EPC STORMWATER REVIEW COMMENTS
IN ORANGE BOXES WITH BLACK TEXT

LOT 53, KING'S DEER HIGHLANDS FILING NO. 5
A PORTION OF THE NORTHWEST QUARTER OF SECTION 4,
TOWNSHIP 11 SOUTH, RANGE 66 WEST OF THE 6TH P.M.,
COUNTY OF EL PASO, STATE OF COLORADO

SITE PLAN

SITE PLAN

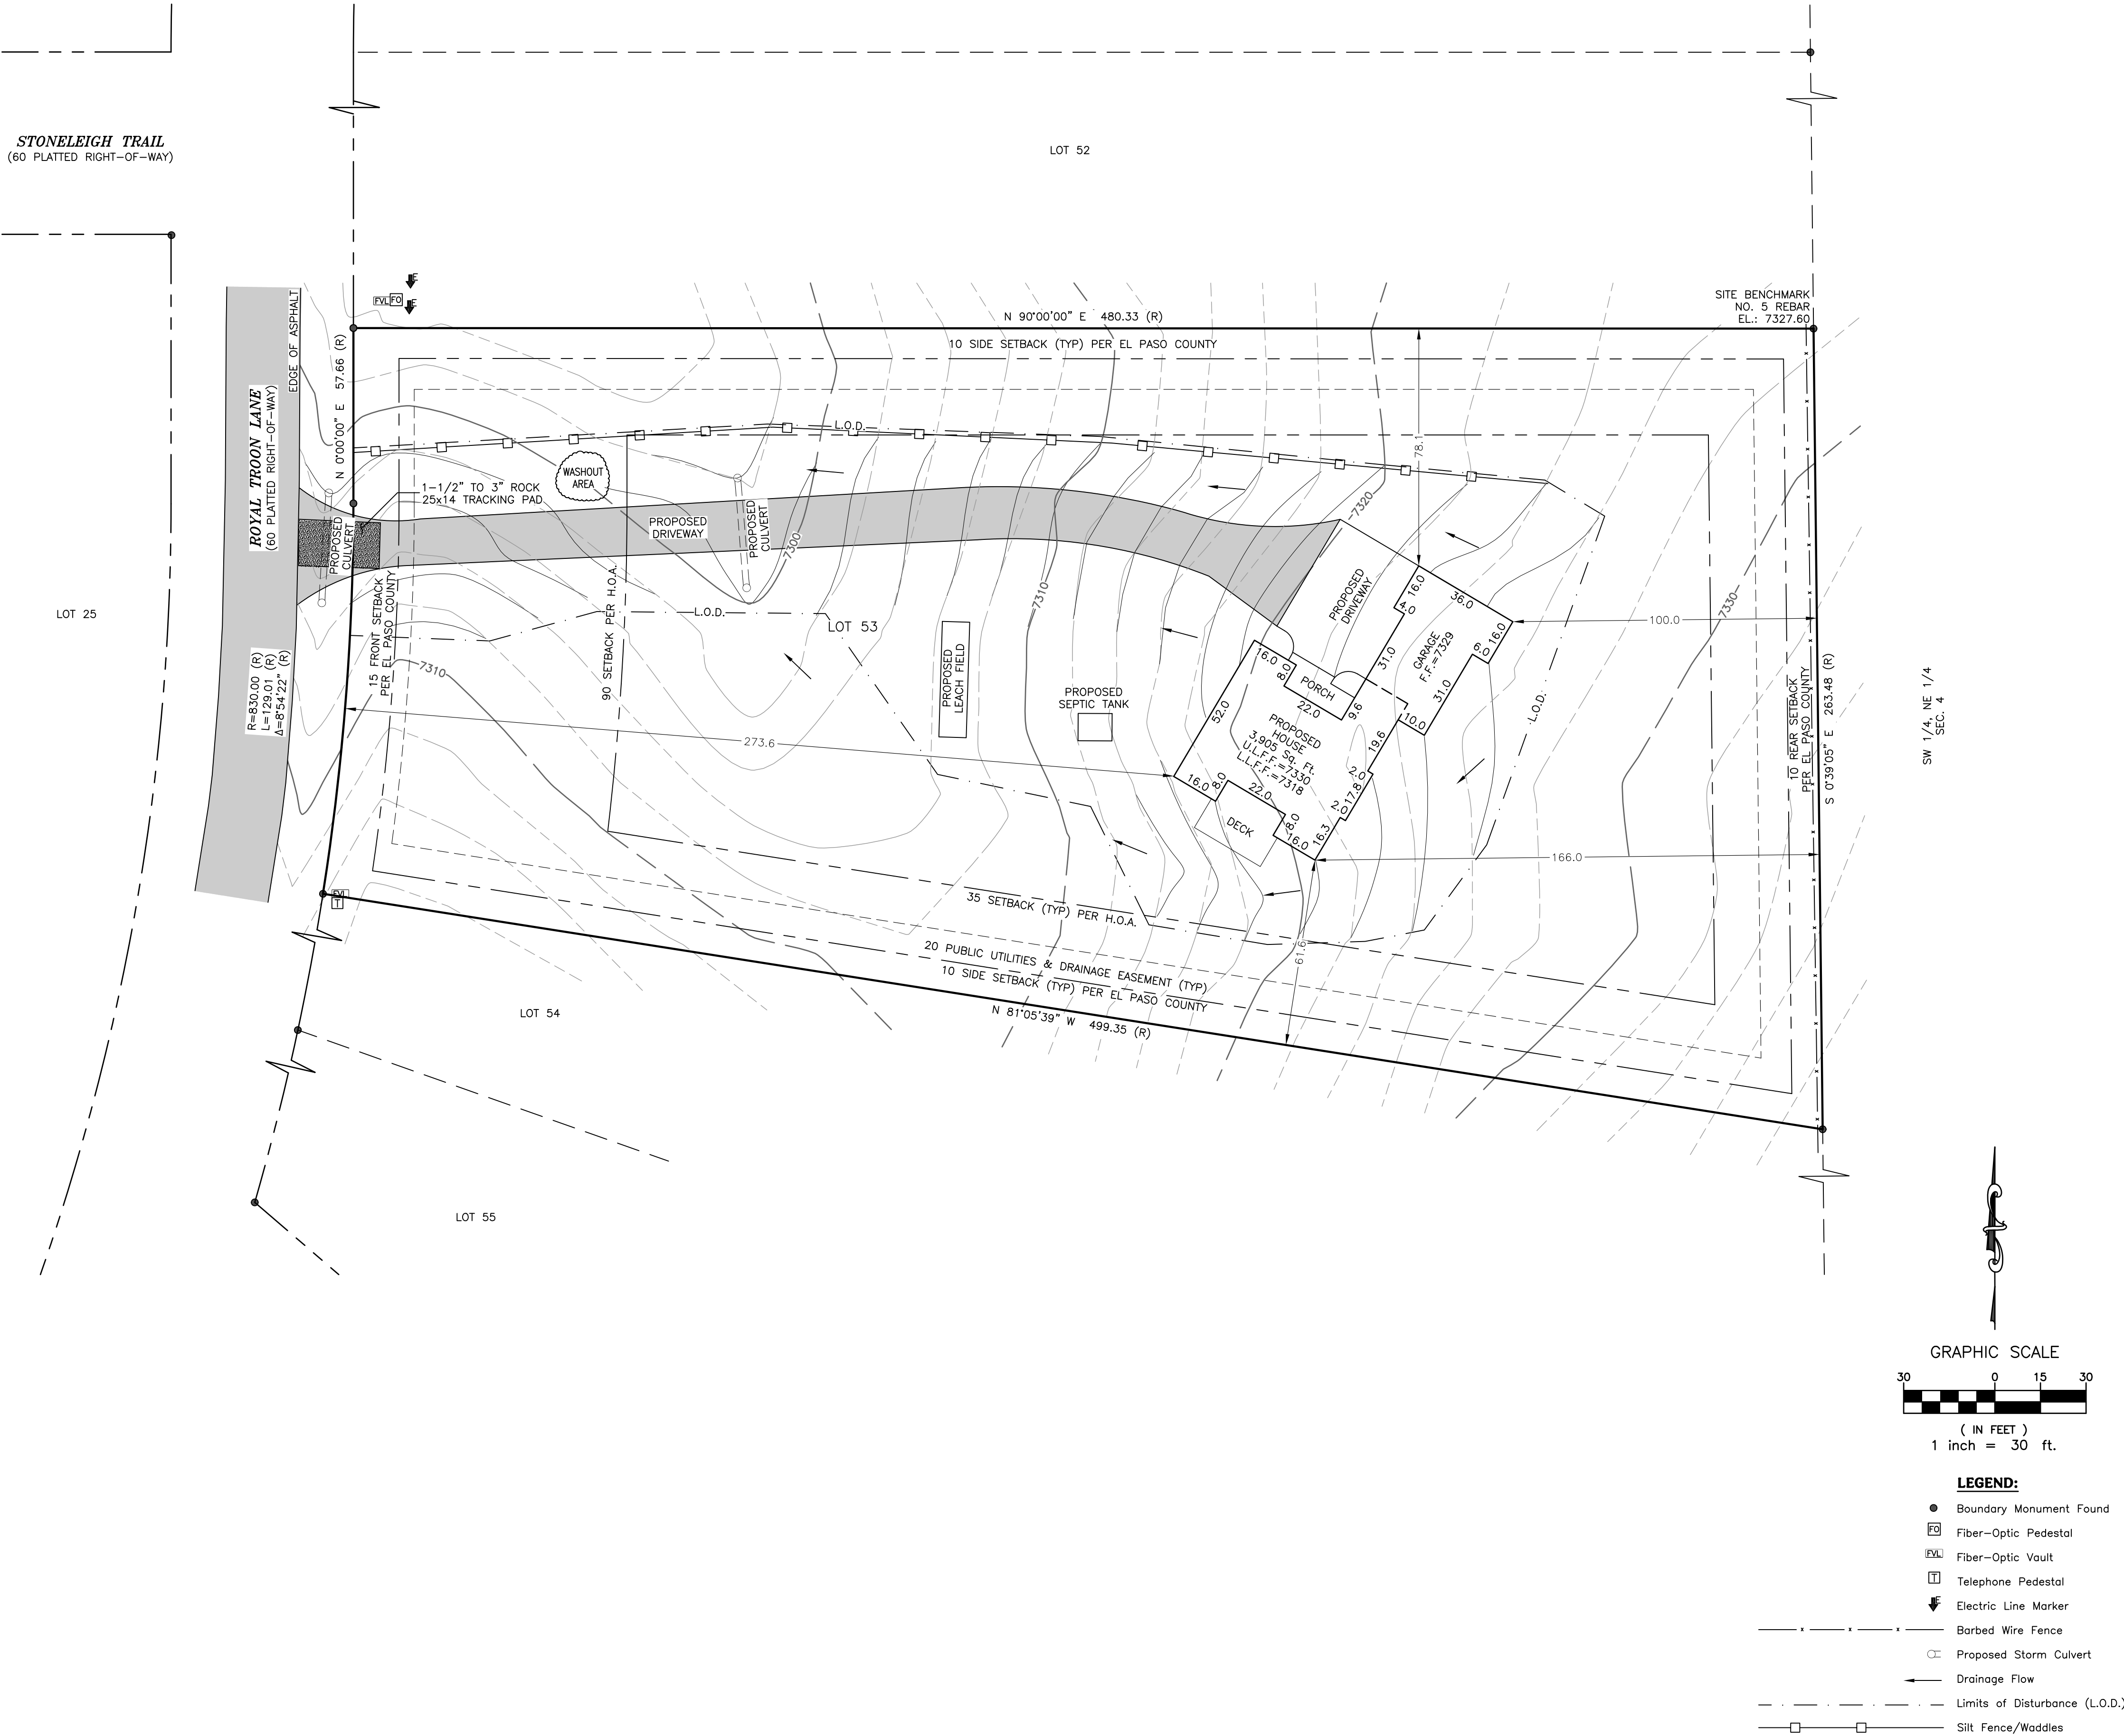
Is the site disturbs over an acre an ESQCP is required which is a more intensive stormwater quality permit. Recommend specifying more realistic limits of disturbance associated with the homebuilding specifically.

When I measure the contour/home building I get around 35,000 sqft which would be less than 1 ac. Verify and get a more site specific disturbance area.

The Site Map must include the following:
- Total percent imperviousness of the site, to include both existing and proposed development in calculation. Consider all structures, porches, decks, patios, driveways, etc.
- Proposed limits of disturbance
- Proposed location of construction control measures (e.g., culvert protection, perimeter control, vehicle tracking control, concrete washout area, etc.)
